Project Name:	Land at Bayards, Eastergate (Miller Homes)
Document Reference:	091.5016/SVR/6.2
Document Name:	SuDS Verification Report – Area 6
Prepared By:	Samuel Flesher
Checked By:	Meagan Weedon
Approved By:	Jon Soar

- 1.1 This Sustainable urban Drainage Strategy (SuDS) Verification Report – Area 6, has been prepared by Paul Basham Associates on behalf of Miller Homes to support the 'As-Built' verification report to Arun District Council in relation to Land at Bayards, Eastergate.

- 1.2 This Verification Report has been prepared to support the discharge of Planning Condition 24. The report authors are Paul Basham Associates Ltd. Paul Basham Associates were established in 2009 and are a multi-disciplinary Transport Planning, Civil and Structural Engineering Consultancy, employing a team of Civil Engineers.

PS5279	Position(M)	Code	Observation	MPEG	photo
 PSCP160	0.0	MH	Start node, ref PS5279	10:14:56	
	4.2	SO	Debris in pipe	10:15:36	
	5.8	MH	Finish node, ref PSCP160	10:15:53

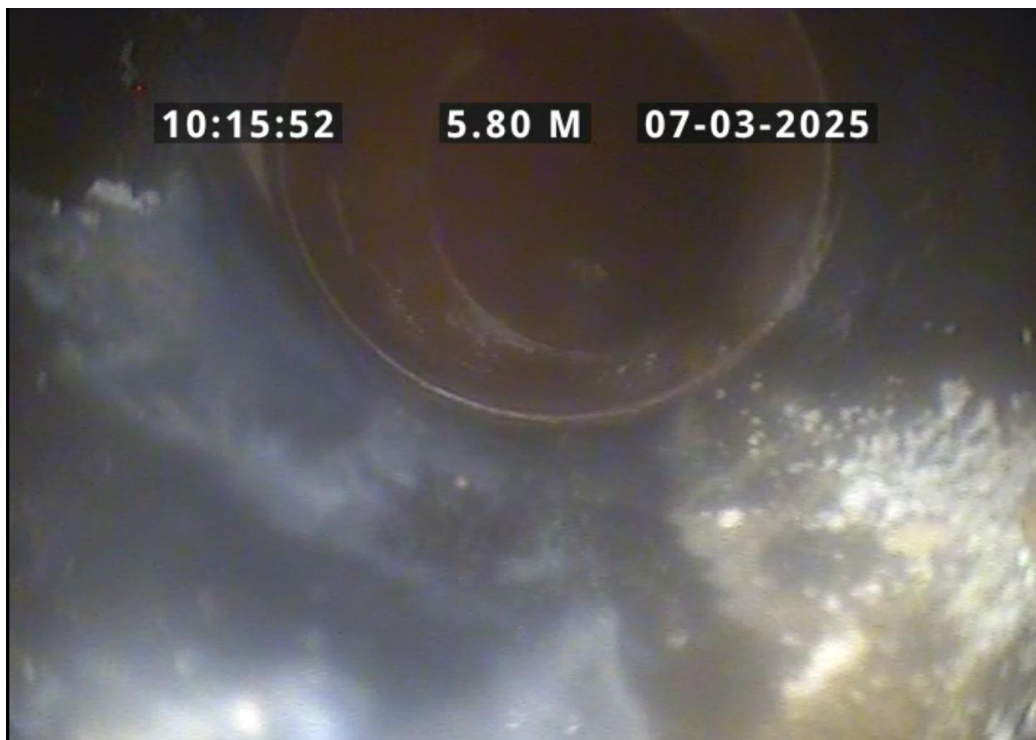
PSCP160-PS5297		Significant amount of sediment build up and potential root intrusion. Pipe requires jetting and resurveying to determine if there is an intrusion.
PSCP160-SA09		The footage appears to be the same pipe as the footage for SA08 and only 2 minutes apart in terms of time stamp. SA09-11 and SA08 would both need to be resurveyed.
PSCP160-PS159		No visible major defects, although unclear if the upstream chamber was installed.

- Investigate the CCTV footage to determine why SA8 & SA9-11 have been allocated to the same sewer and resurvey.
 - Jet the sewer which showed signs of root ingress and resurvey.

Start node, manhole, reference: PSCP170

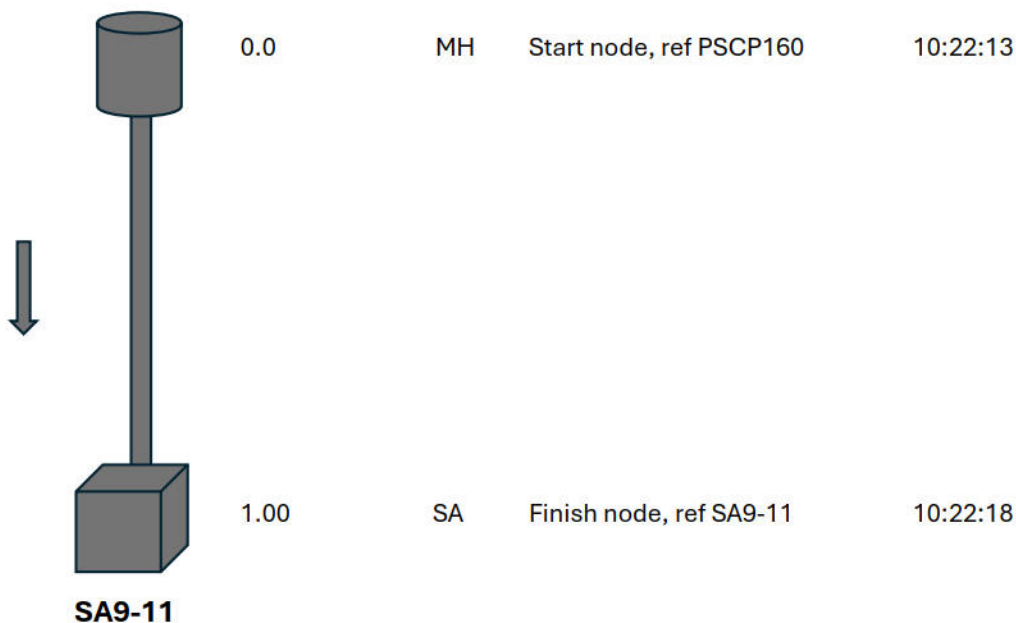
Ref	Defect Images	Comments
PSCP170-PS169		Pipe appears to have no visible major defects. End of survey appears to be upstream manhole as not a catchpit which should be installed immediately upstream of connection to soakaway.
PSCP170-SA6-7		Pipe appears to have no visible major defects and connects into side of crates as designed
PS23-PSCP165		Significant sediment build up at the end of pipe, suggesting that the pipe may flatten out at connection into downstream manhole.
PSCP165-SA08		Footage is incomplete and it appears the full pipe has not been surveyed
